Our ref: DOC20/132959

**RE: Comments on Response to Submission report for Dendrobium Coal Mine Extension Project (SSD-8194)**

The following document was reviewed to provide comment in this letter (RTS report):

*Dendrobium Mine – Plan for the Future: Coal for Steelmaking, Submissions Report*, prepared by South32, dated February 2020.

### FIGURE 7

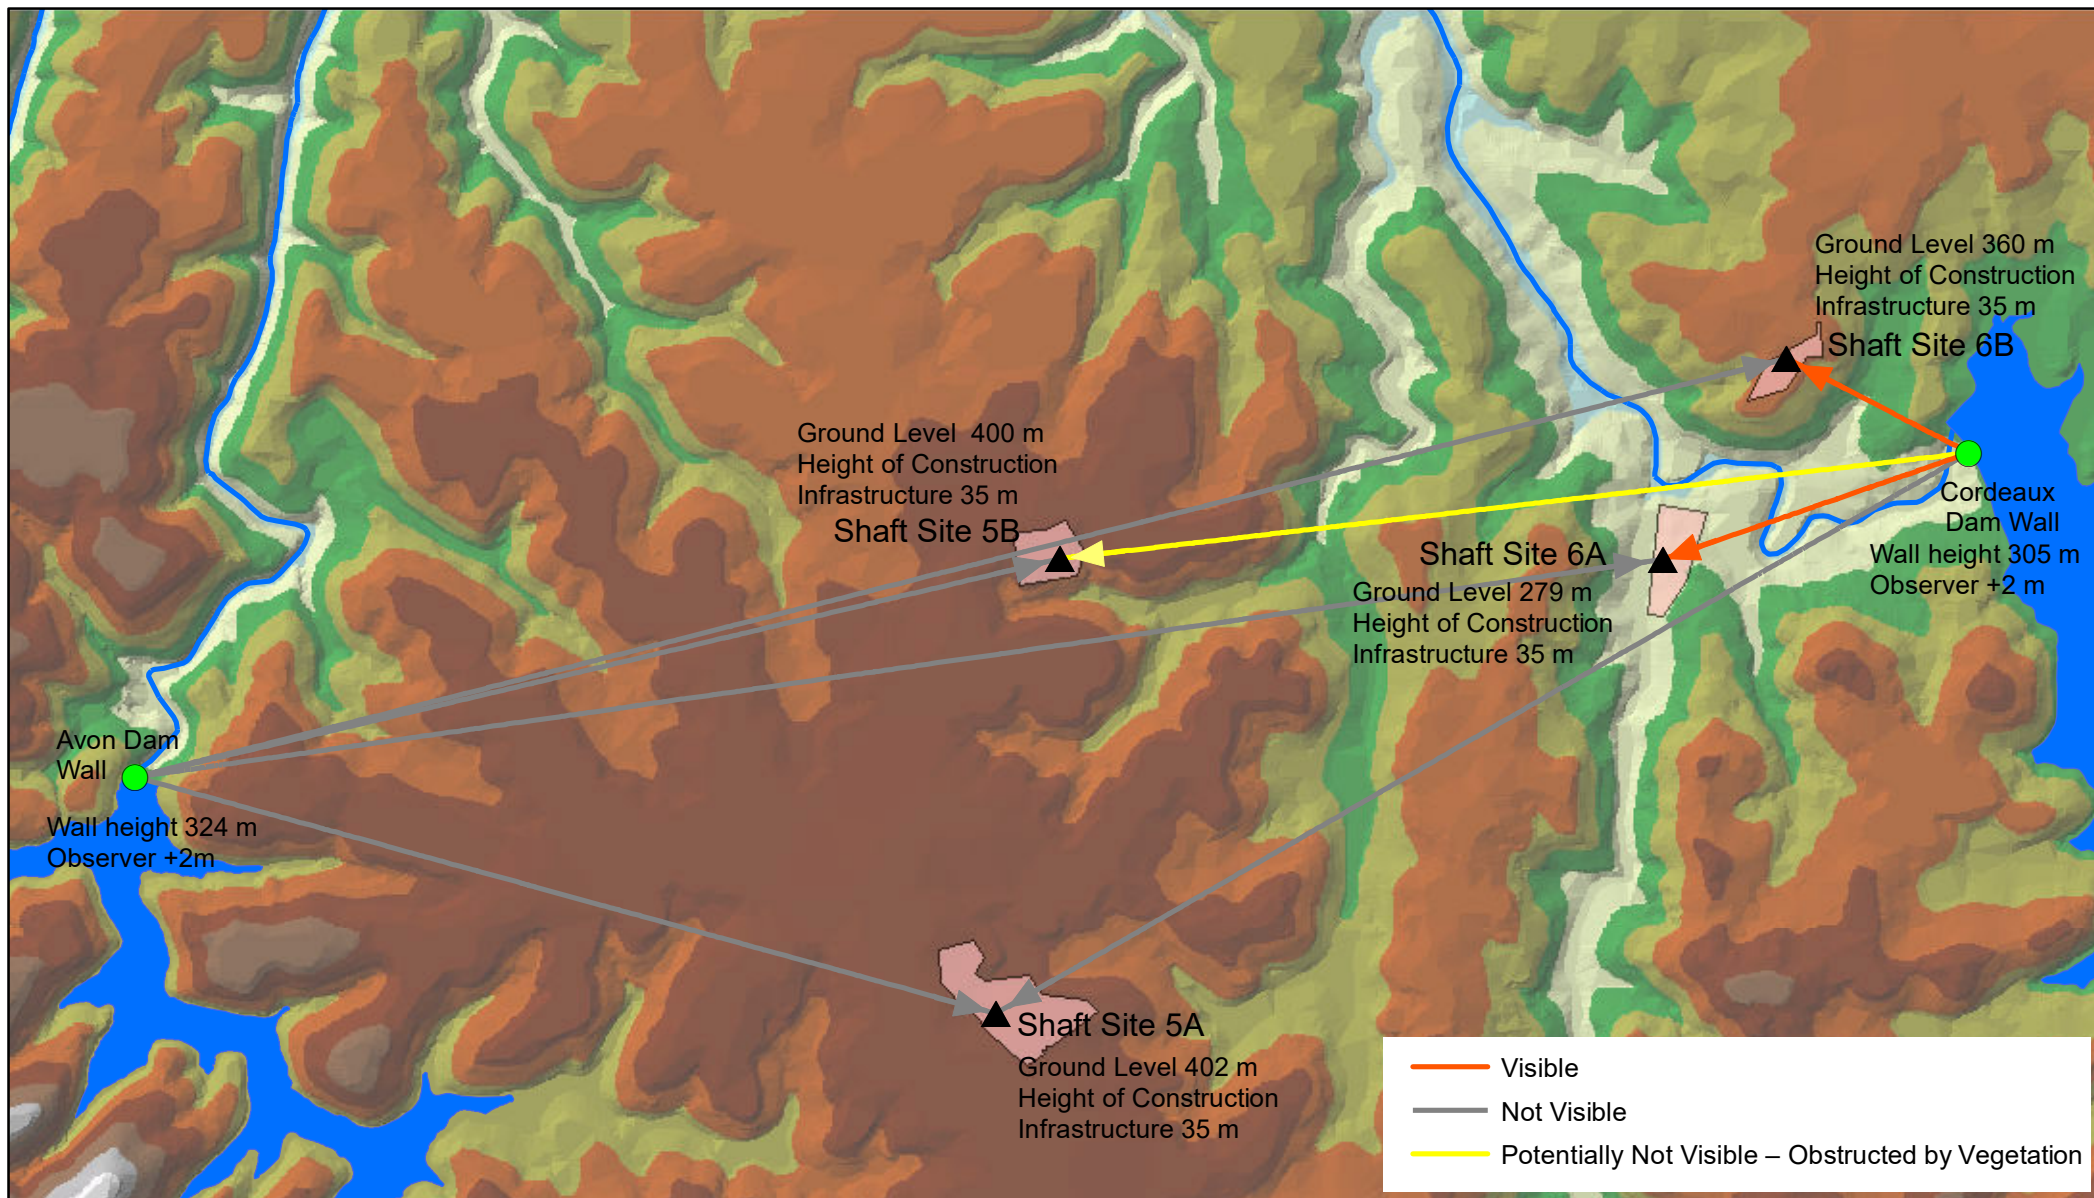
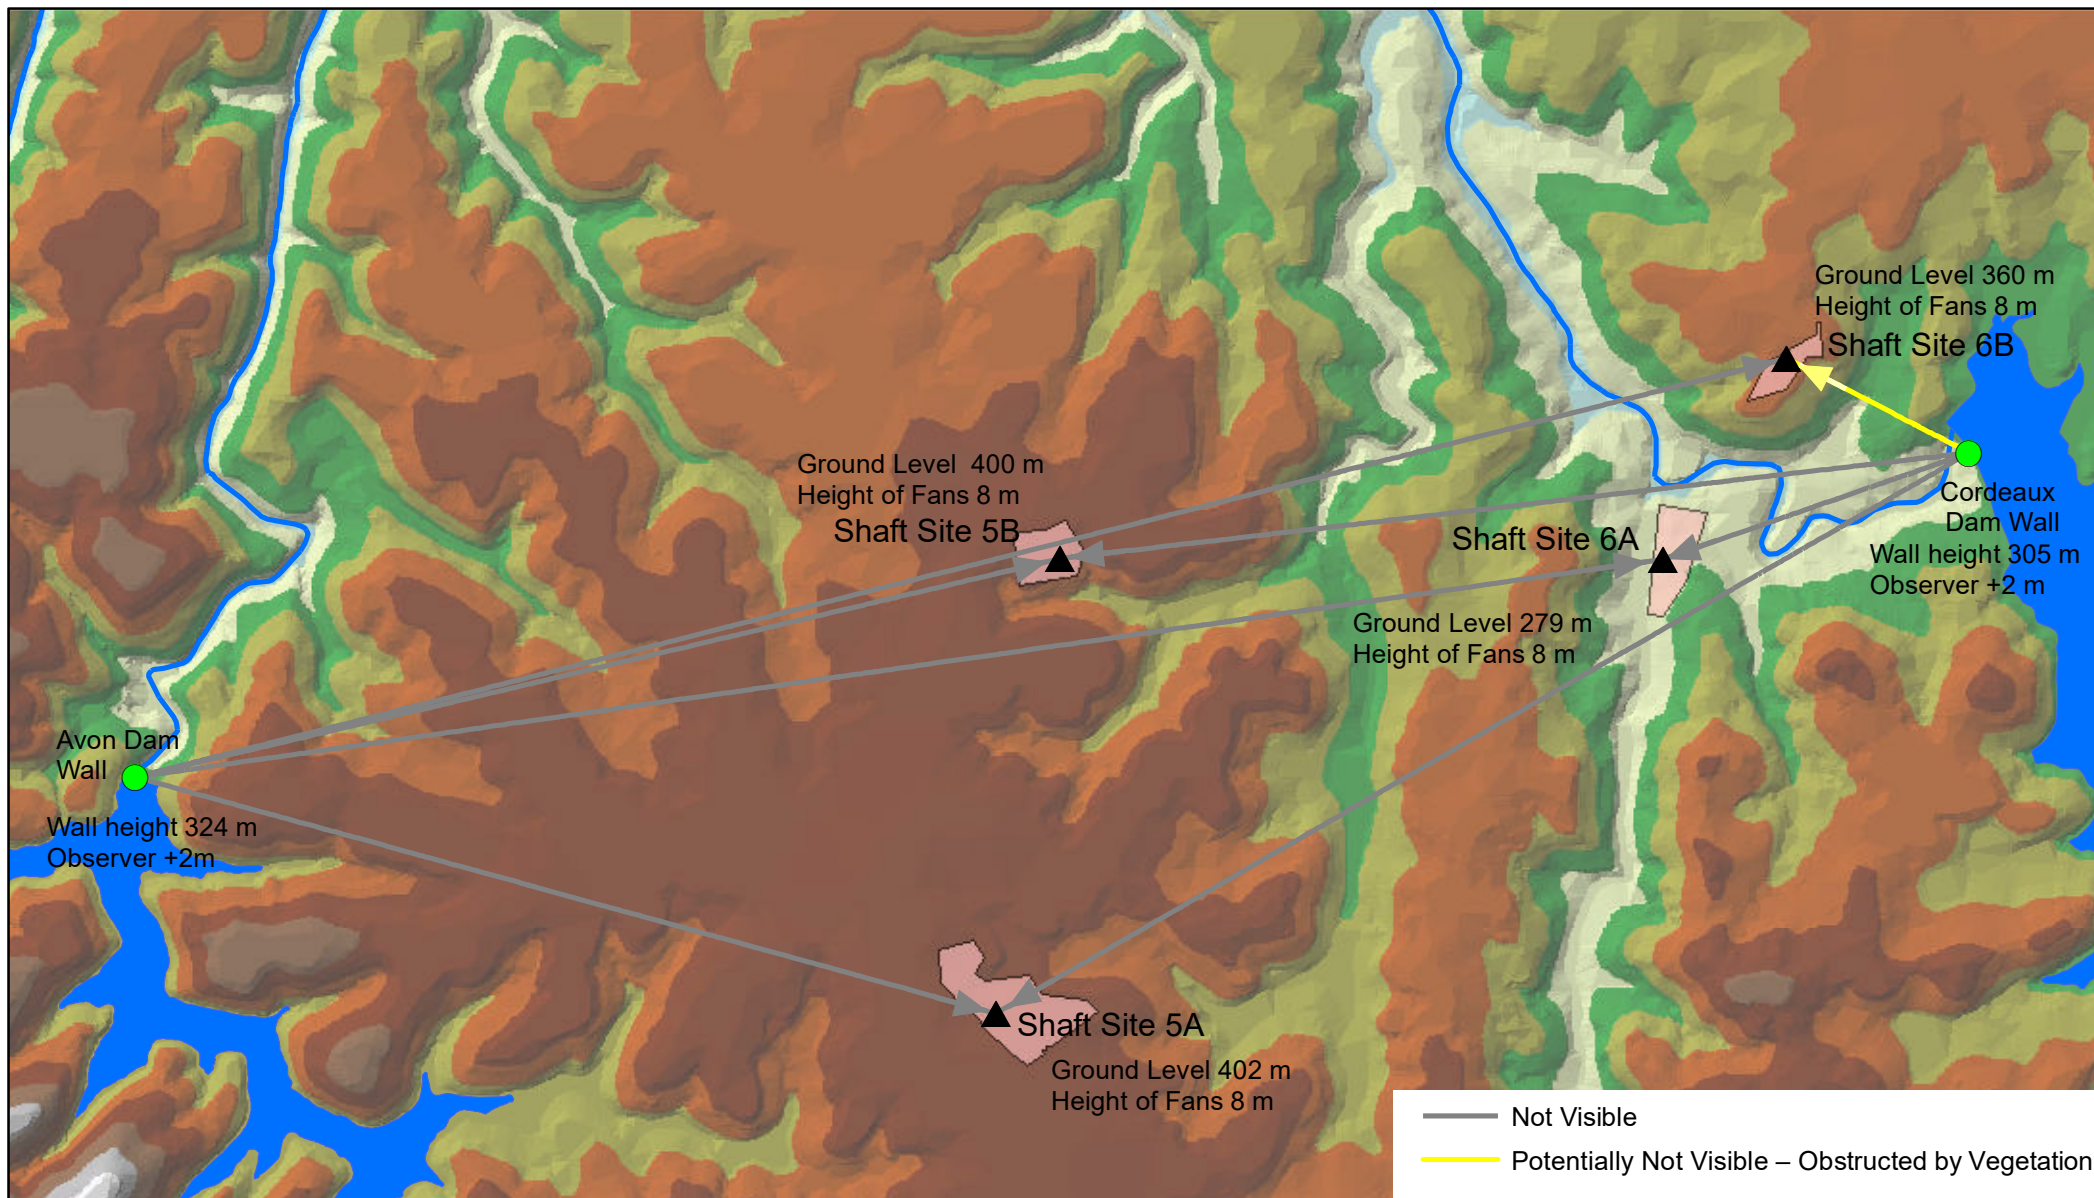
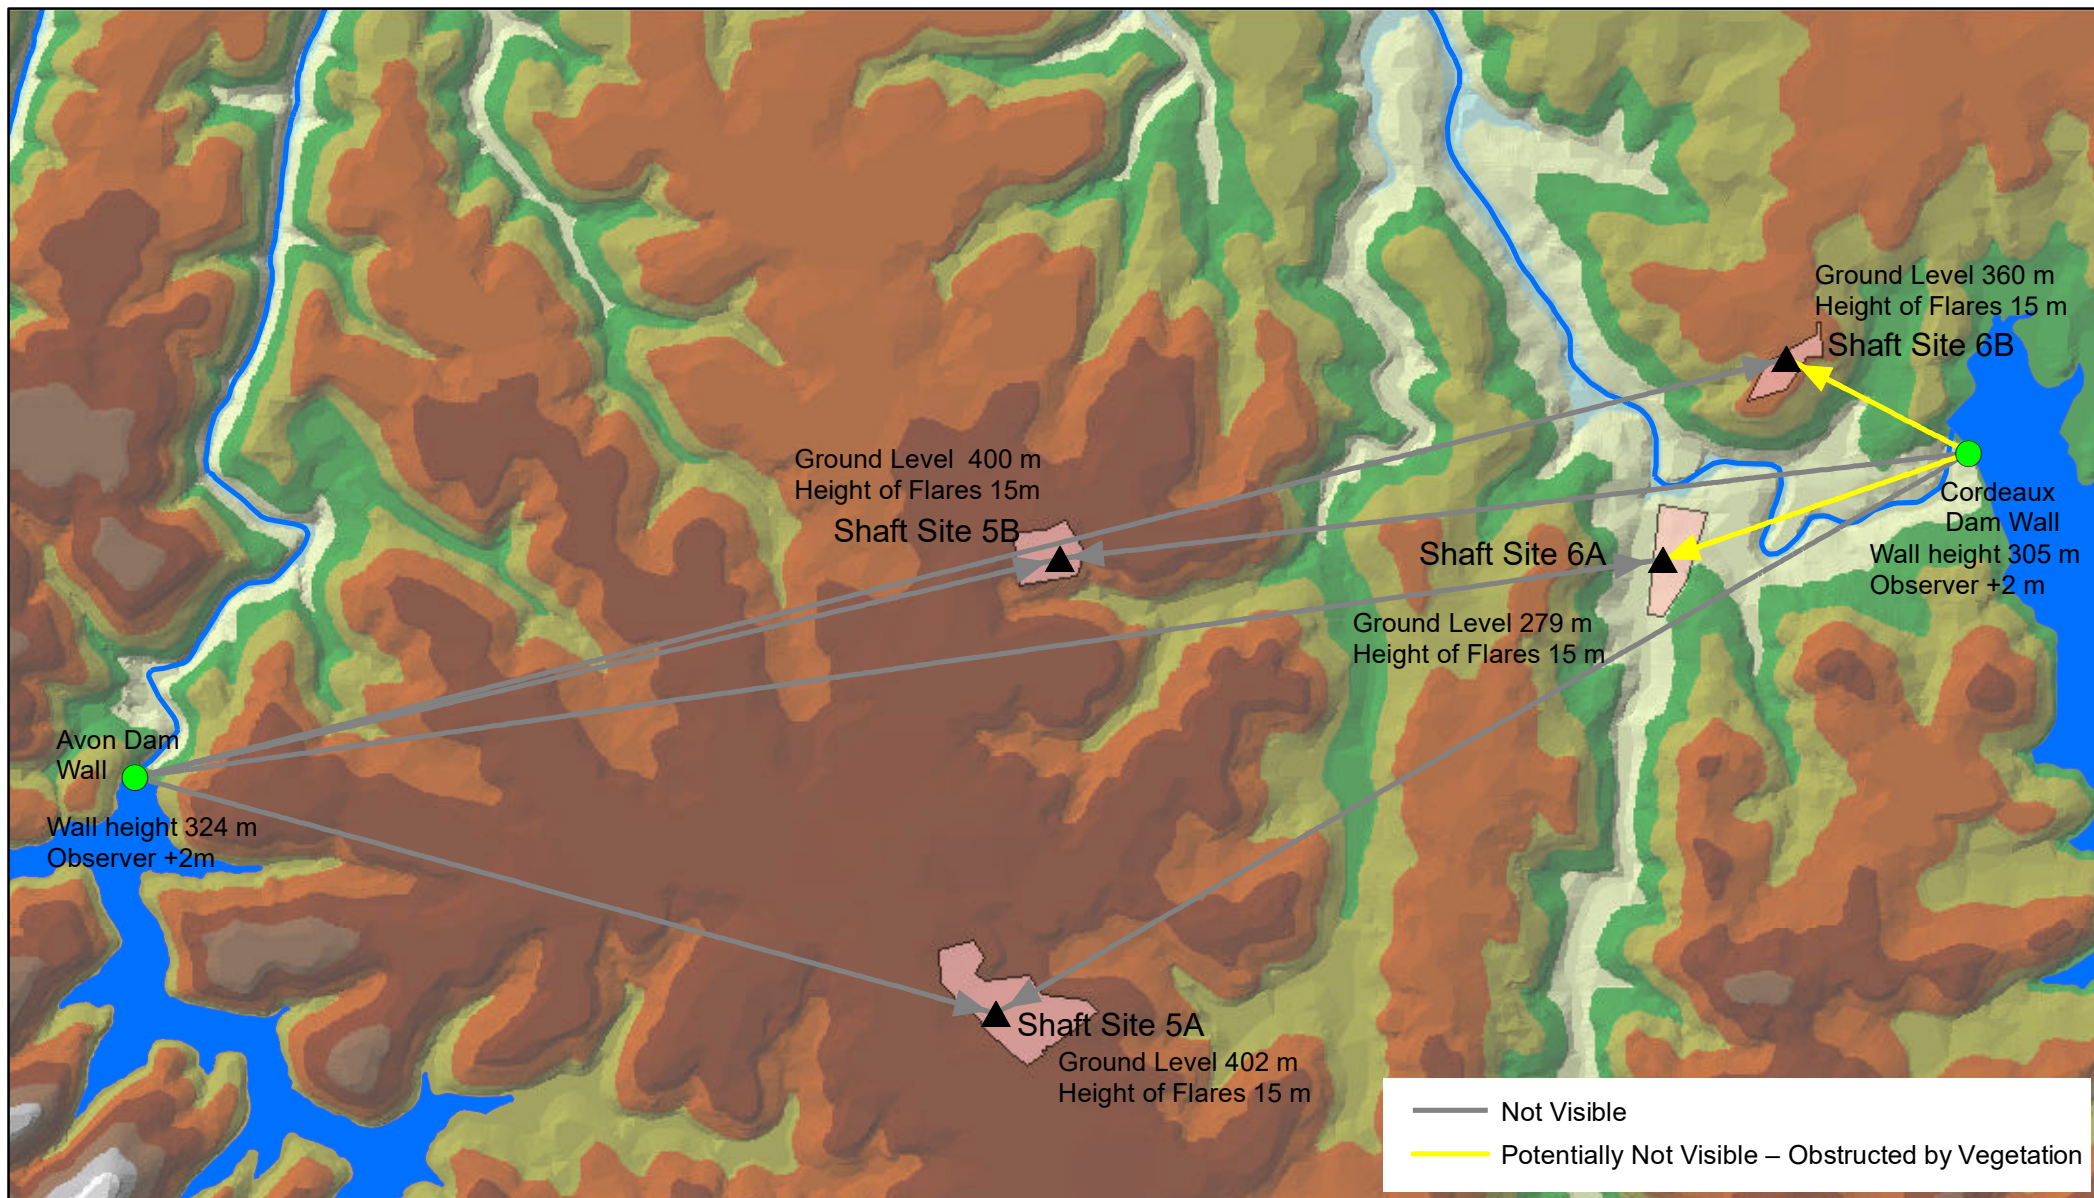
- The RTS report does not provide clarification as to the location of the proposed ventilation shafts in relation to the SHR items or to the visual representation of these shafts. The report suggests that the shafts would be visible from the dam walls during construction, while it also states that these views would be obscured by vegetation during the operational stage of the project. Even though the report subsequently states that these shafts would not result in adverse impacts on the visual amenity or heritage values of the Avon and Cordeaux dam walls, insufficient information has been provided to the Heritage Council to assess these impacts. No further clarification has been provided in relation to the impact of the ventilation shafts upon view points, other than from the dam walls.
